Application # 07-50016953 R

Lot 17 Hunters Point
81 Henry Rifle Lane
07-50016953

Regarding: Hunters Ponds, Lots 16+17 (4 pages)

HUNTERS POINT
LOTS 16 & 17
PROPOSED SEPTIC

HUNTERS POINT
LOTS 16 + 17
PROPOSED SEPTIC

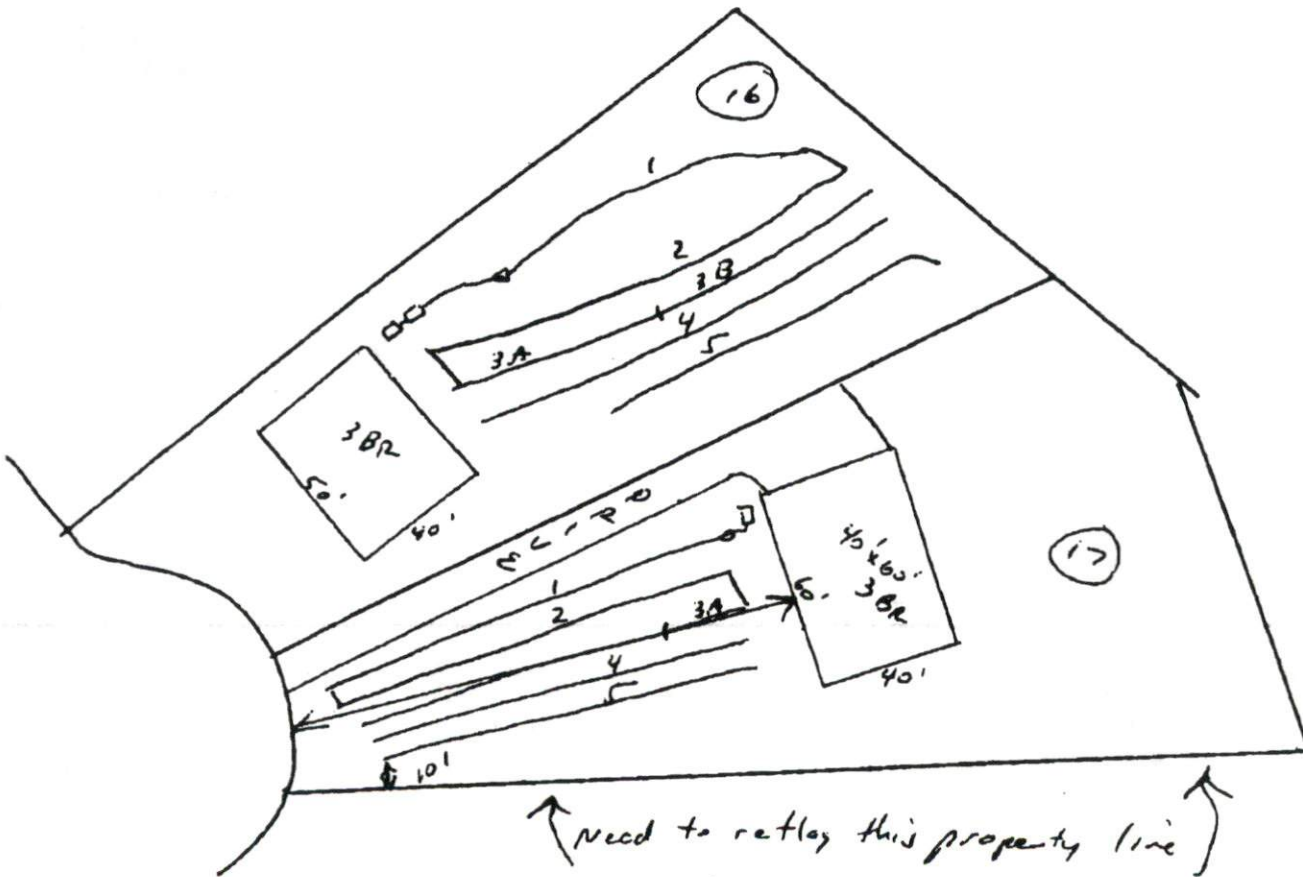
* ② Lot 17 needs to be revised with a 142' house setback. You will also need to reflag lower property line (as shown) to verify location. It may need to be slightly adjusted to maintain 10 ft. Please submit new plot to HARN CO.

Need to retrace this property line
+ adjust into common area
if necessary

⊗ 142' HOUSE SETBACK ON
LOT 17
